Wollongong Private Hospital Expansion

State Significant Development Assessment Report (SSD-84096206)

August 2026

The abovementioned points are shown in the height blanket analysis provided within the Architectural Plans prepared by CM+ and HPI (Annexure 8), and in the plan extracts at **Figure 2** to **5** below.

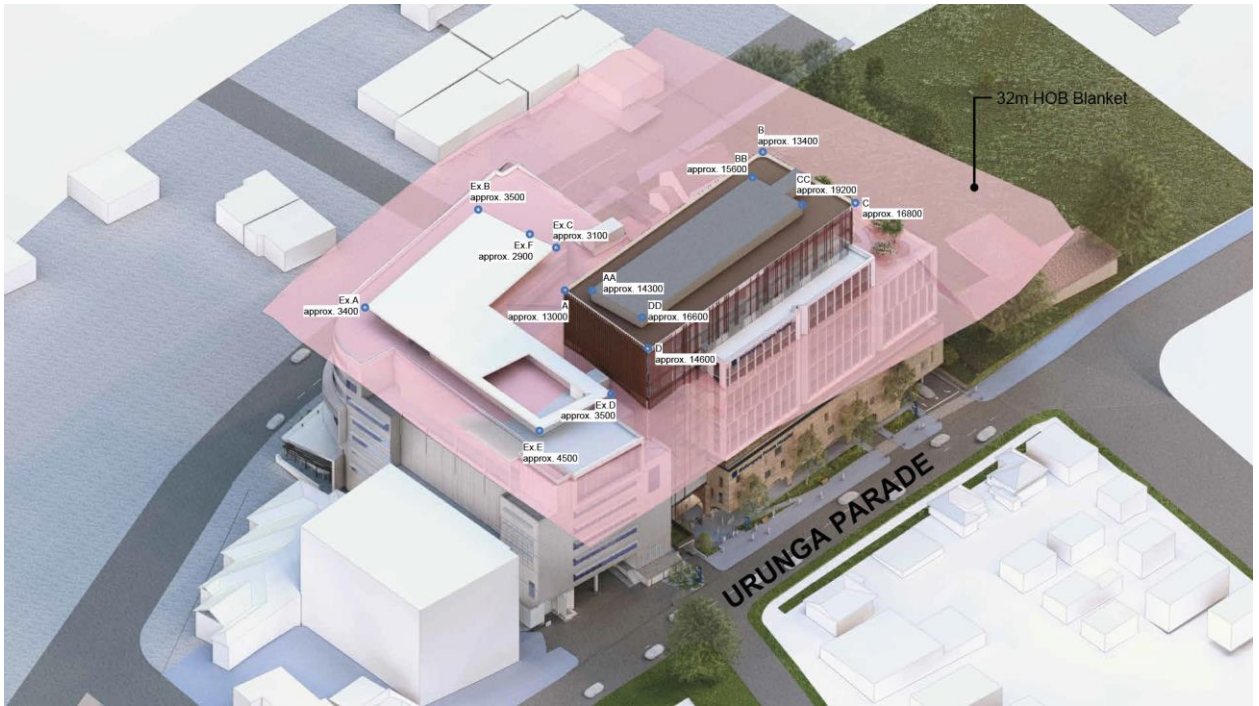
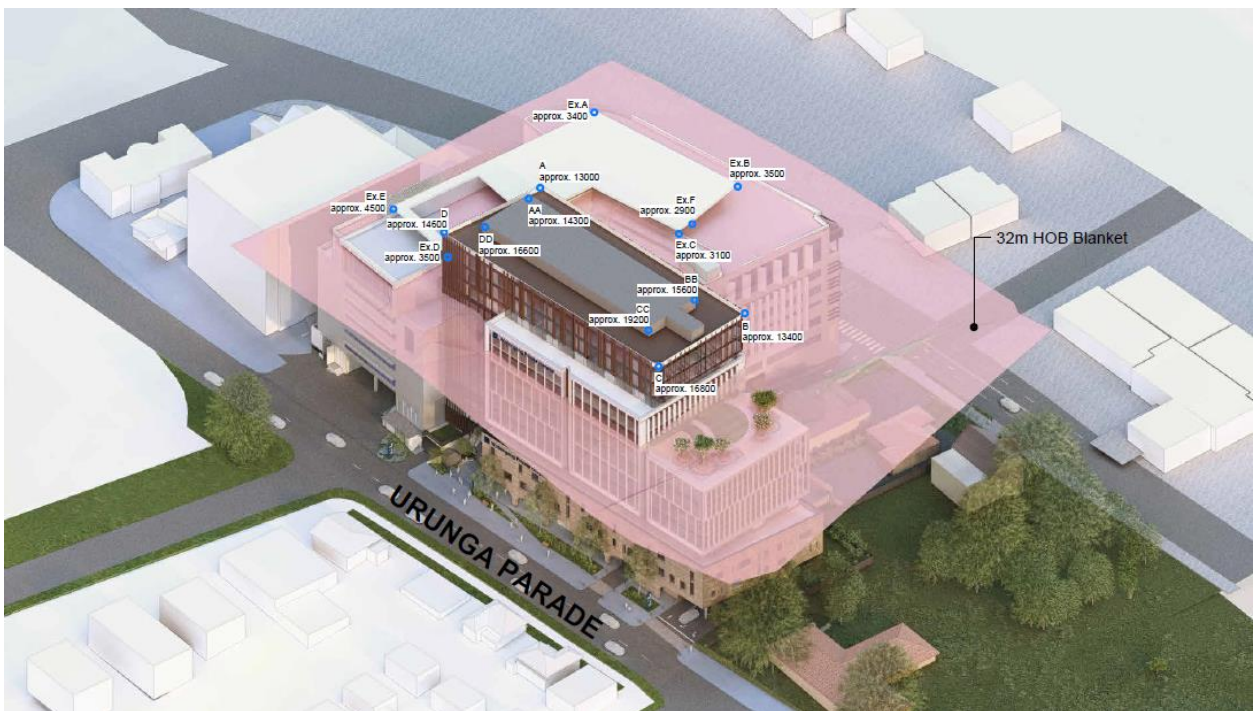
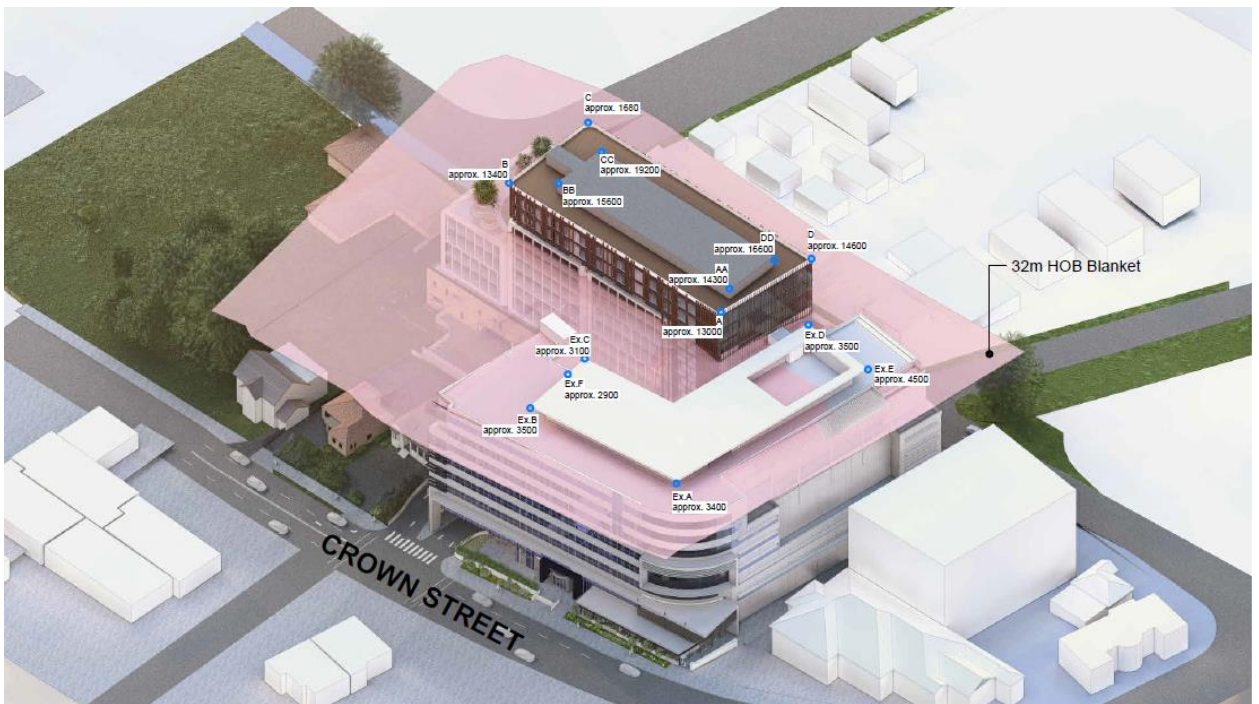
- the Applicant has not demonstrated that compliance with the WLEP height and FSR standards is unreasonable or unnecessary, and therefore consent cannot be granted pursuant to clause 4.6 of the WLEP.

- there are insufficient environmental planning grounds to justify the height and FSR variations, and therefore consent cannot be granted pursuant to clause 4.6 of the WLEP.
